Arun District Council
Arun Civic Centre
Maltravers Road
Littlehampton
West Sussex BN17 5LF
Planning & Building Control General Enquiries
Tel: (01903) 737756 Fax: (01903) 730442
Dx: 57406 Littlehampton
Minicom: 01903 732765
e-mail: planning@arun.gov.uk
website: www.arun.gov.uk/planning

Application No: FG/196/21/HH
Site Address: 9 Telgarth Road Ferring BN12 5PX
Description of works: Erection of single storey side infill and rear extension, hip to gable roof extension to include 2 x side dormers, installation of front porch canopy and alterations to fenestration/openings.

Thank you for your internet representation made on 30th December 2021 which has been recorded as an objection with the comments as follows:

A :: Proposed North Elevation
02 scale: 1:100

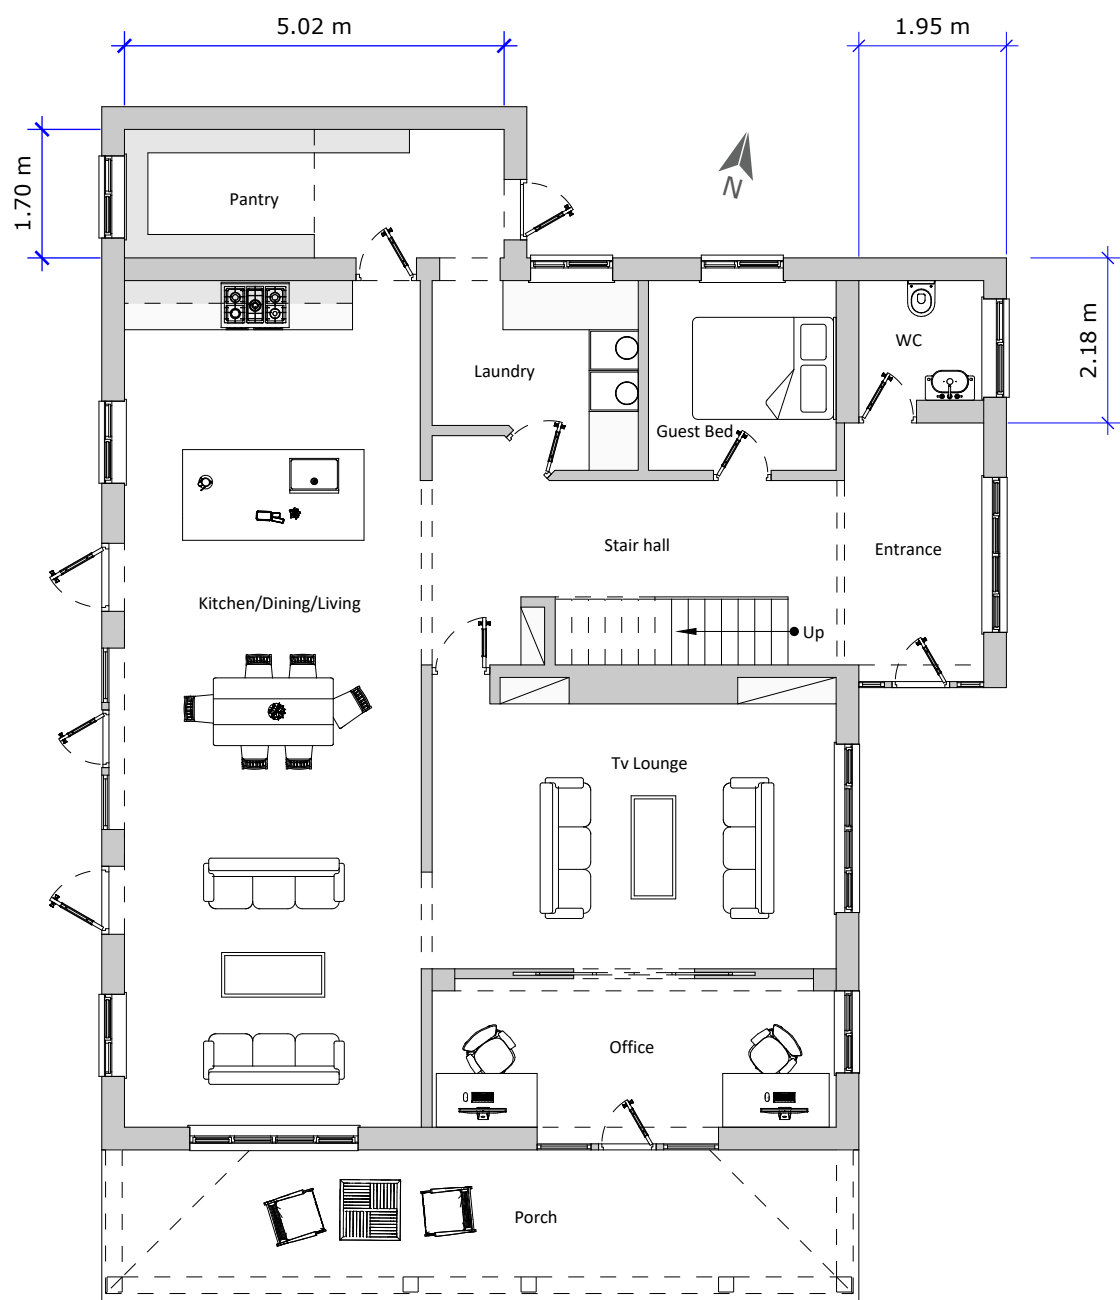
Dormer Roof light window to north elevation will give direct line of sight into our main bedroom, degrading our privacy. If fixed window with obscured glass as alternative, that would be ok. Size of overall works to roof will reduce our overall light from SE through S and to SW over prolonged period of daylight thus degraded our quality of life and enjoyment of our property.
